Subject: Planning Consultation on: FP/13/20/PL

FP/13/20/PL

The Applicant wishes to make alterations to Arun District Council's seawall to enable direct access to the promenade. Coast Protection has no other interest in the application but we strongly **object** to the alteration of the seawall. The seawall provides flood protection to Clyde Road and allowing alterations to the seawall would compromise the integrity of the defence. Of course, I have no doubt that the access could be designed in such a way to provide a robust defence but allowing uncontrolled access poses a significant problem for Arun District Council. By allowing the Applicant to install direct access to the promenade Arun District Council would no longer be able to control, and therefore provide, defence for the remaining properties along Clyde Road.

PROJECT The Beachcroft Hotel - Terrace
TITLE Proposed Site Plan
SCALE As Noted
DATE 11/01/20
DRG NO IBA/526/02
REVISIONS A

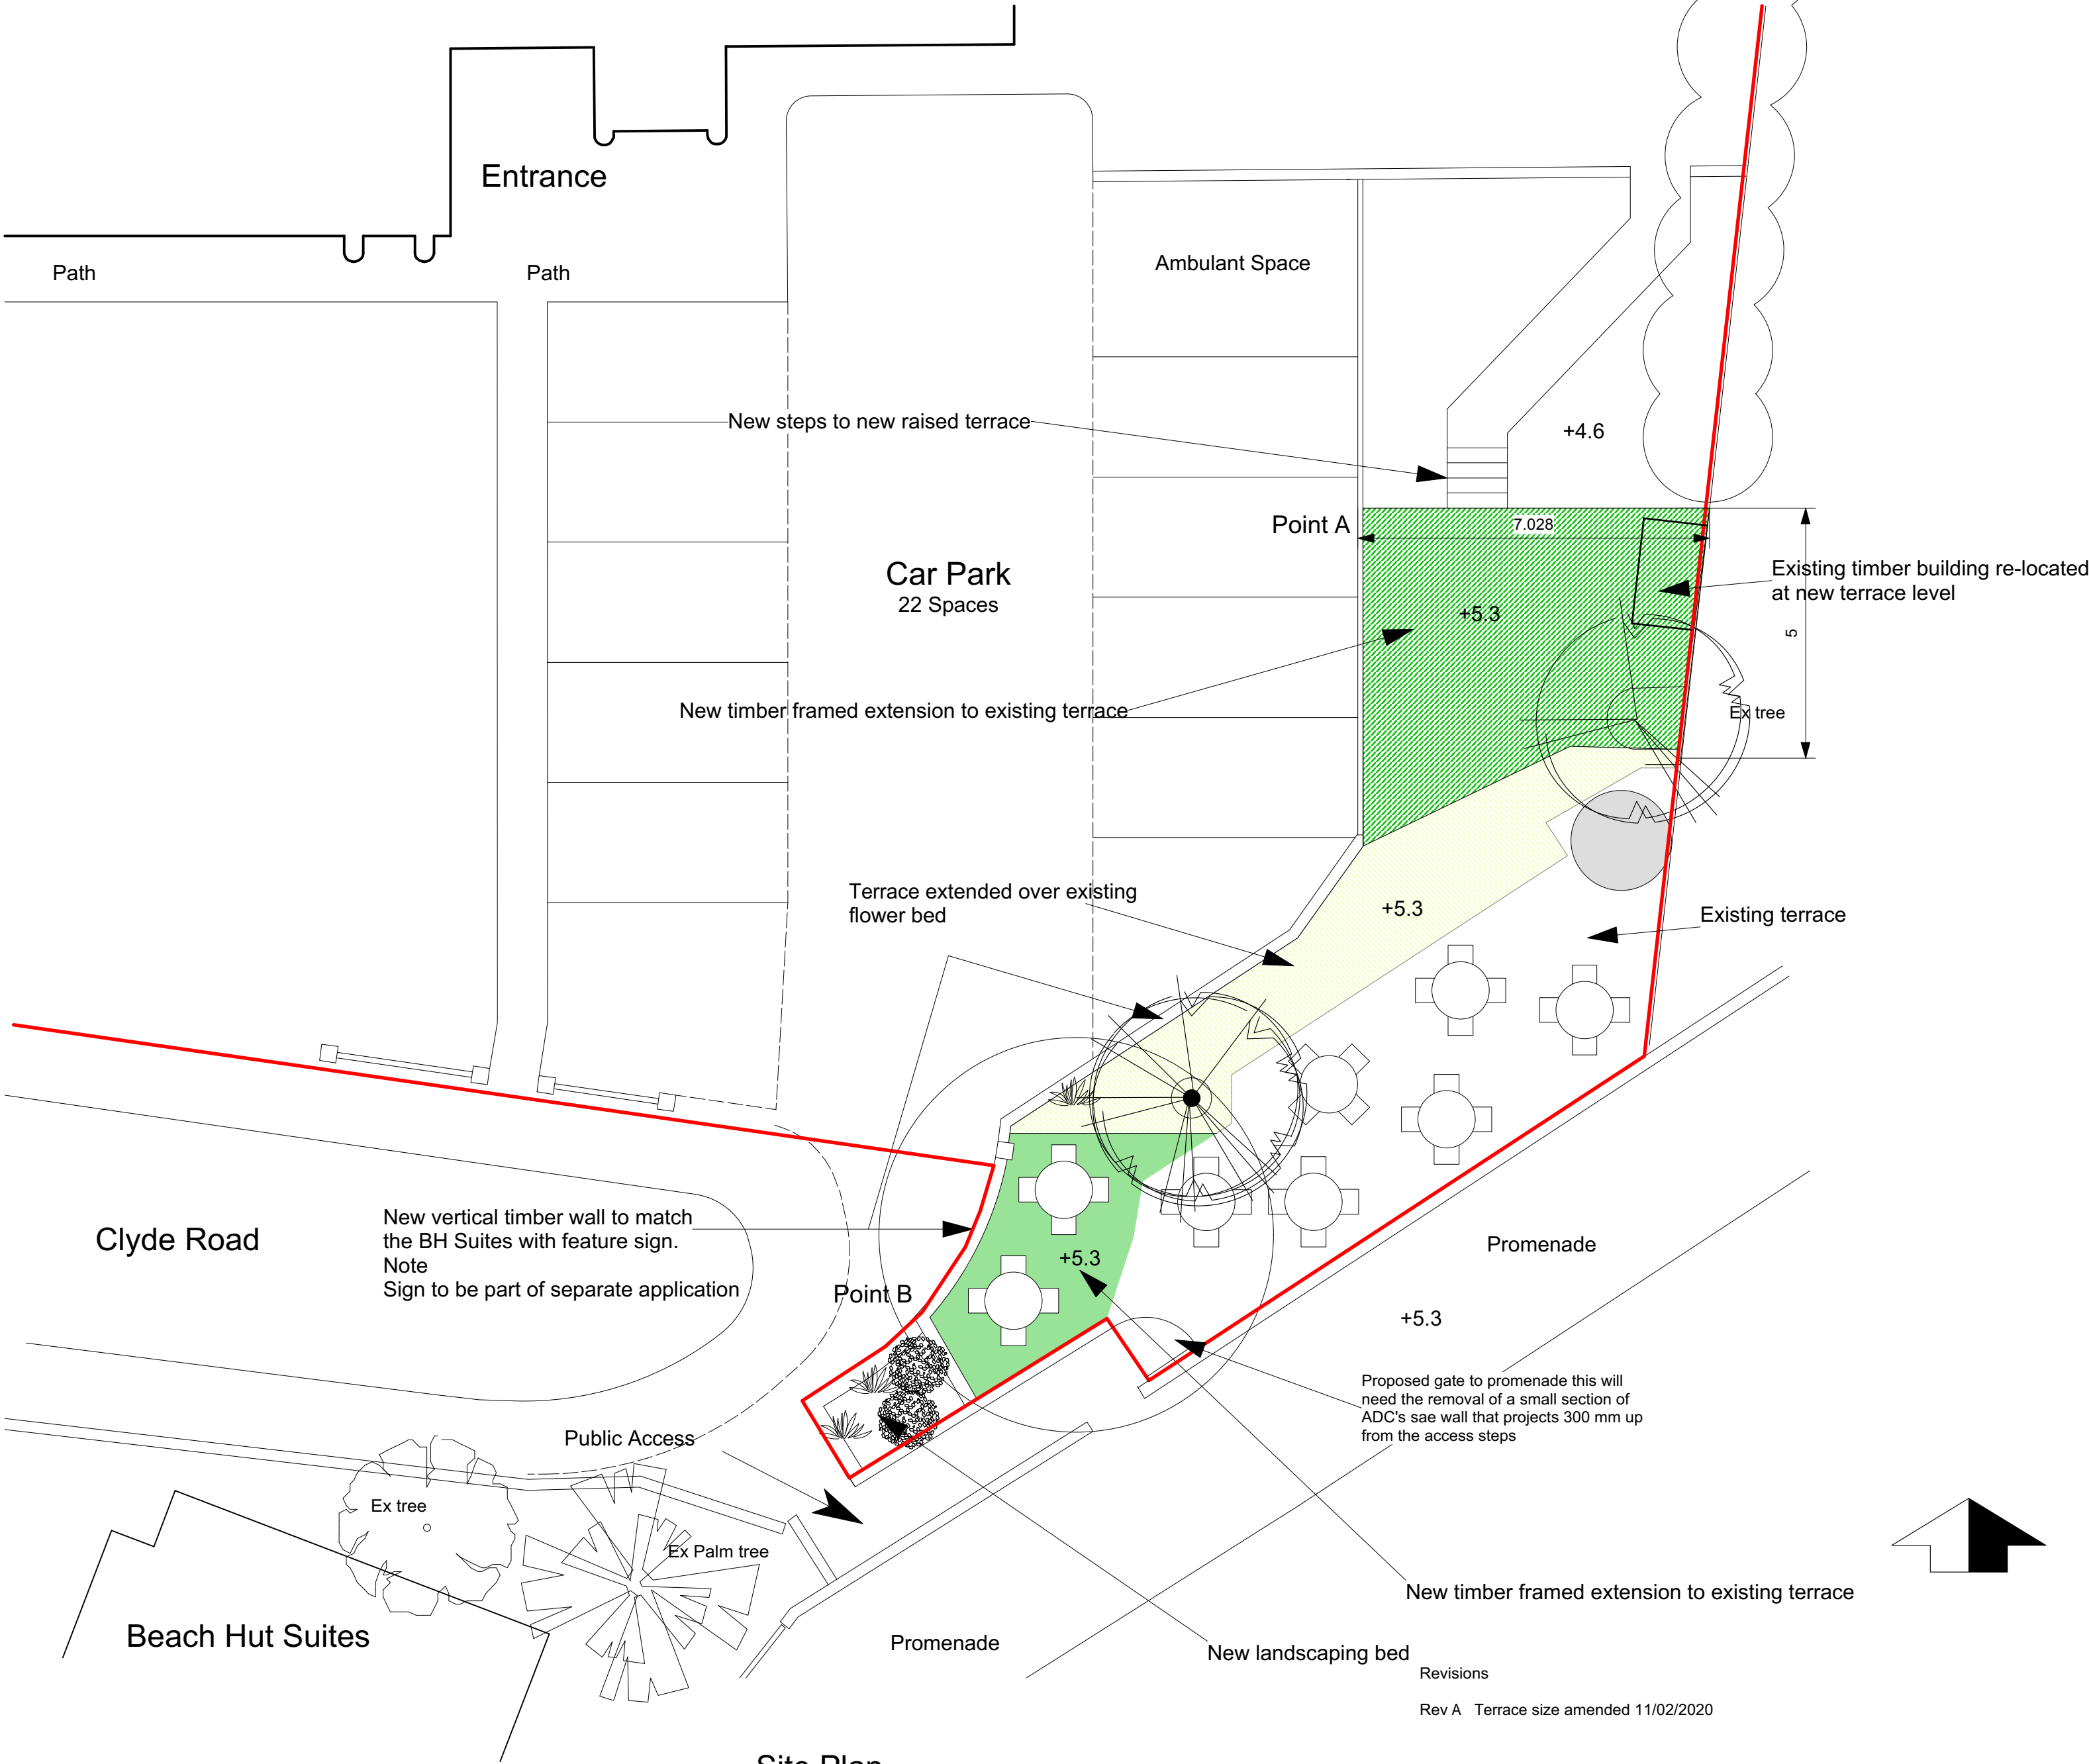
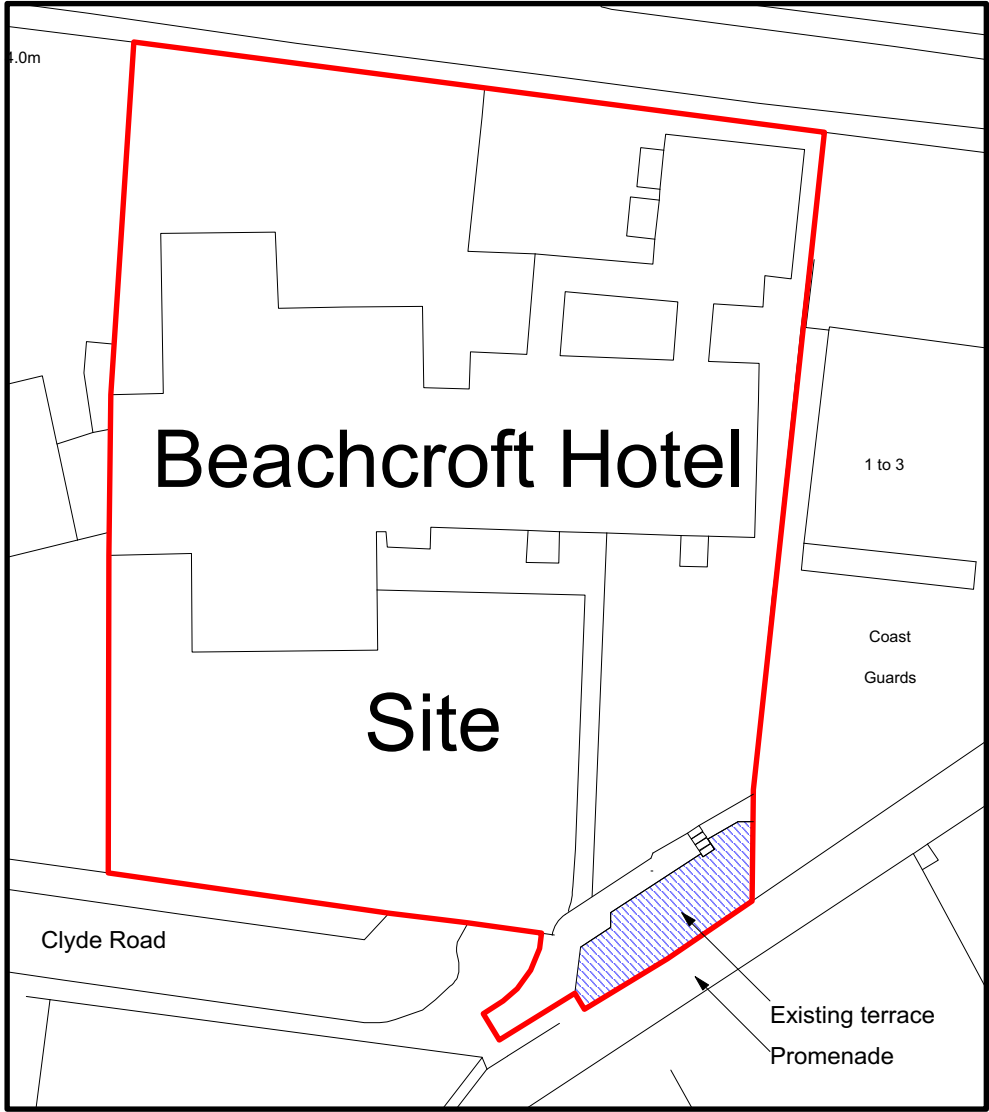
With Sea Level Rise & Climate Change, we should be seen to be strengthening out coastal defences not potentially weakening them.

Equally, the area at the top of the pedestrian access would become chaotic and further investigation would need to determine what alterations would need to be made to ensure compliance with the Equality Act 2010.
